El Paso County Planning and Community Development

Re: Falcon Marketplace Preliminary Plan (SP-17-001) Response 6

Please accept this response letter to your review 4 comments dated August 27, 2018.

LANDSCAPE PLAN - AREA 'A'

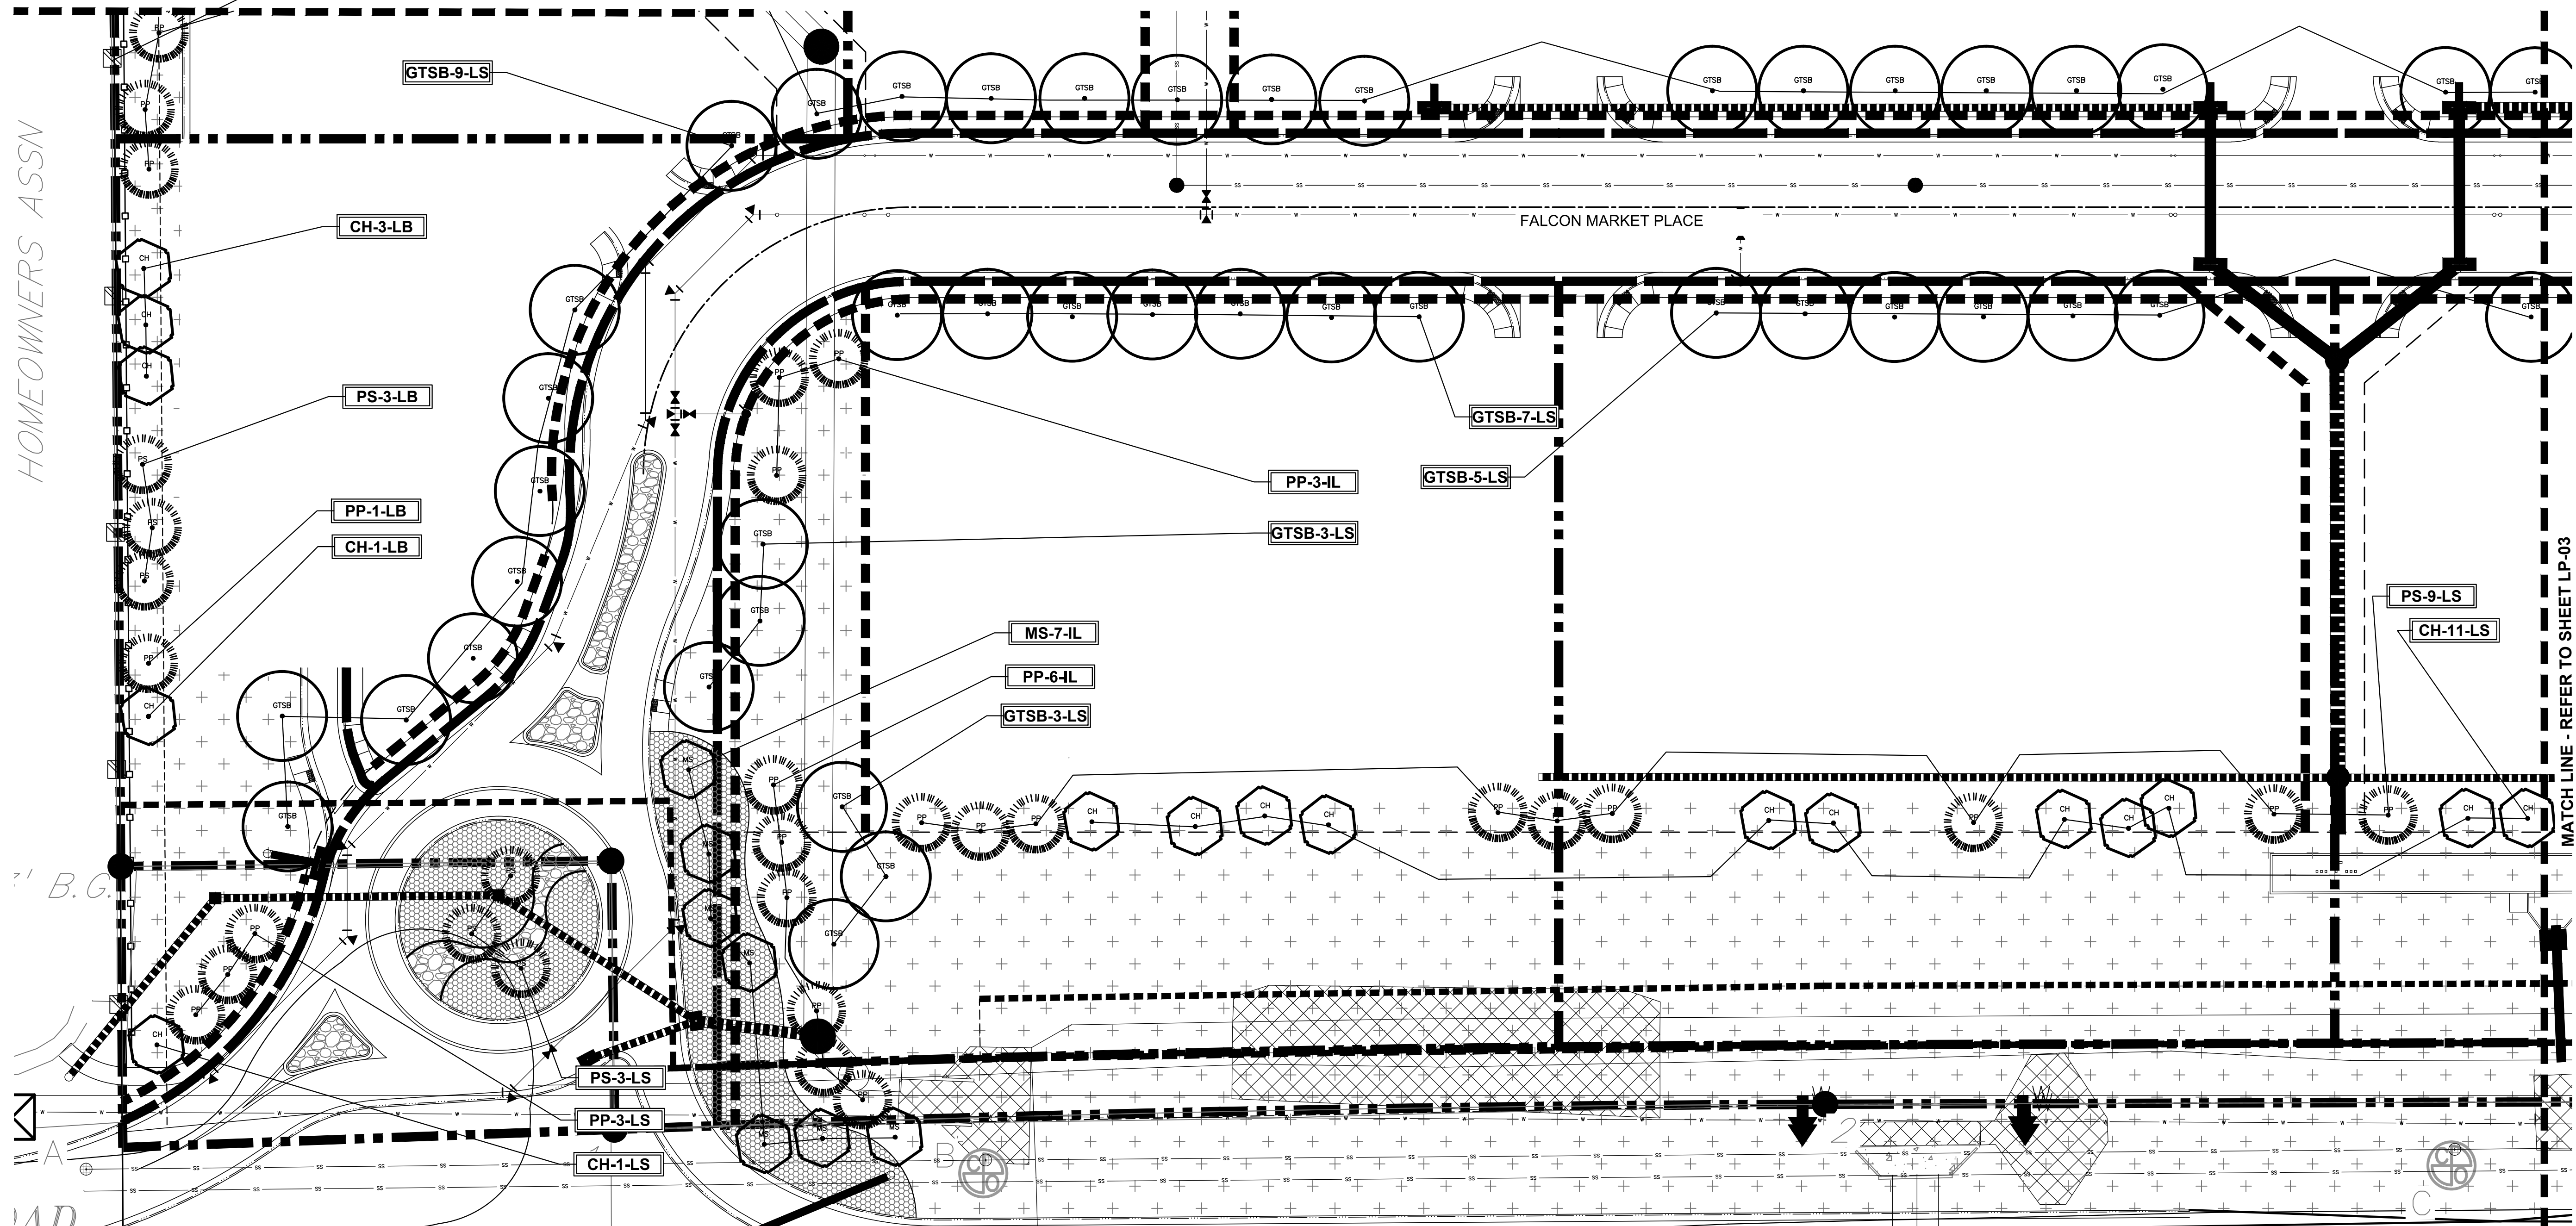
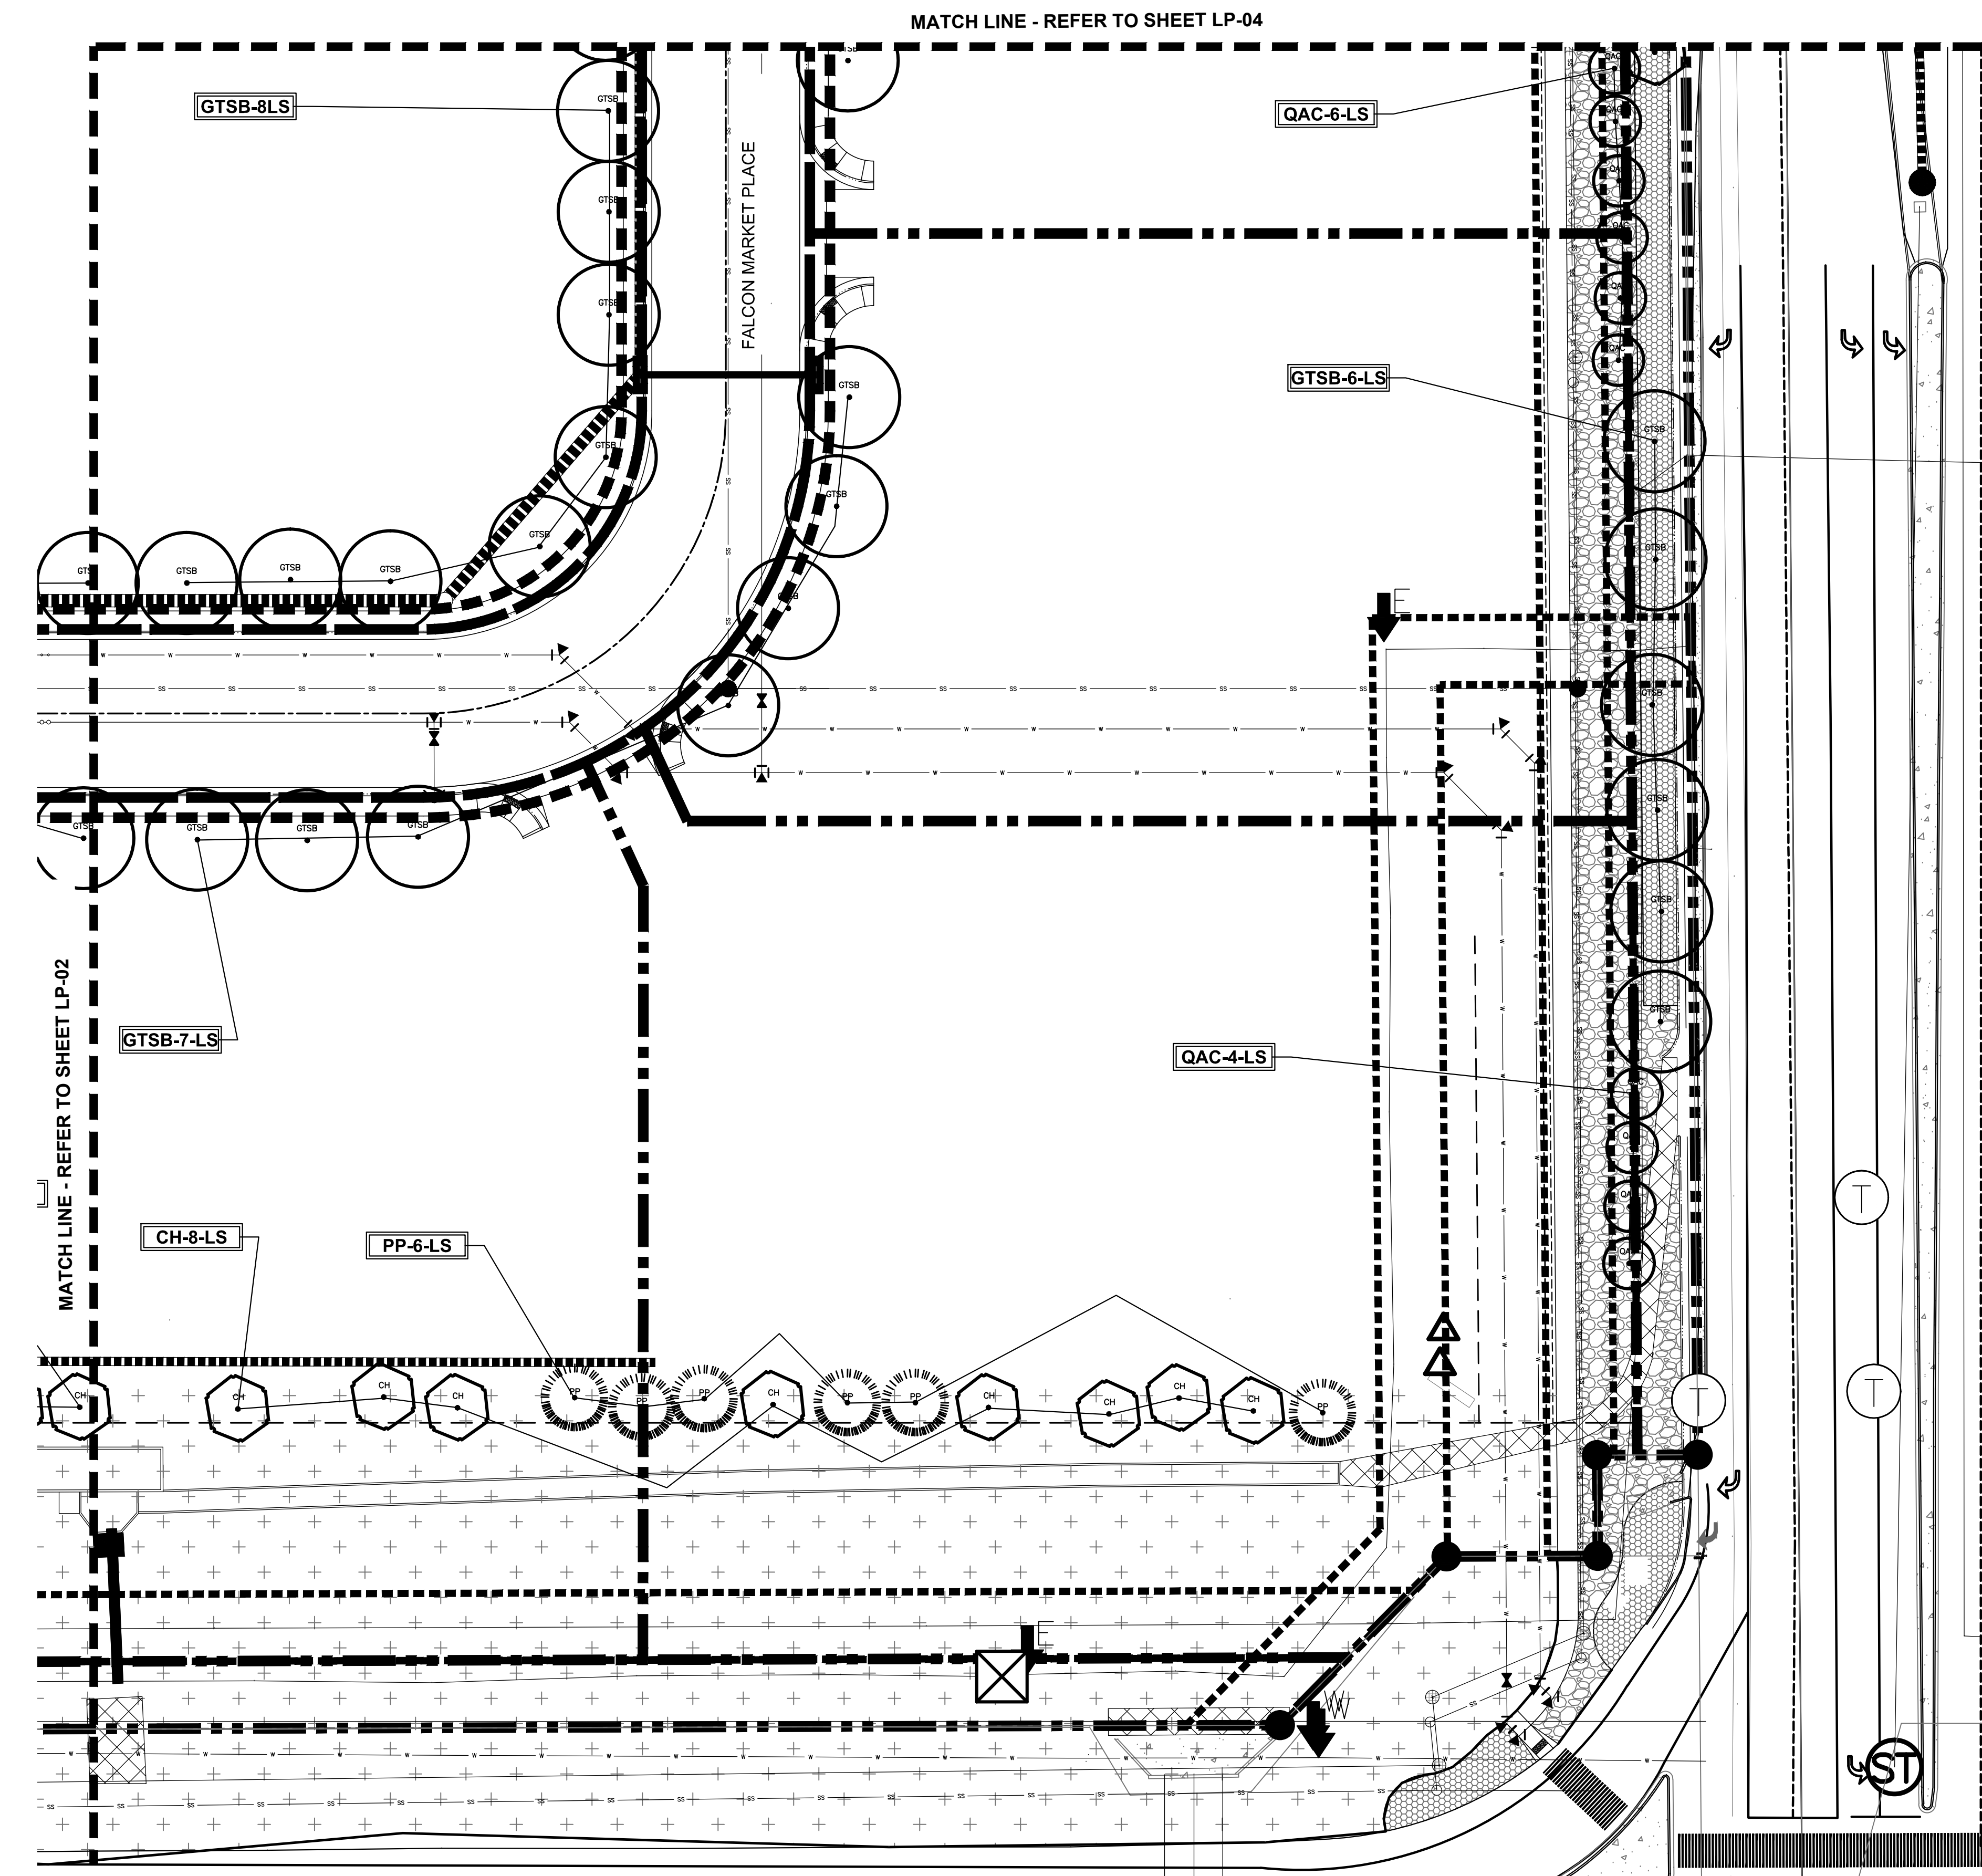
13. The landscape plan included with this submittal shows trees in existing and proposed ROW in several areas including along Meridian Road. Some of these trees need to be moved depending on final site design and construction plans. A license agreement will be required at the final plat stage for private landscaping remaining in the ROW, including the proposed roundabouts. Comment remains. **Comment remains.**
Landscape plan adjusted after conversation review with Staff.
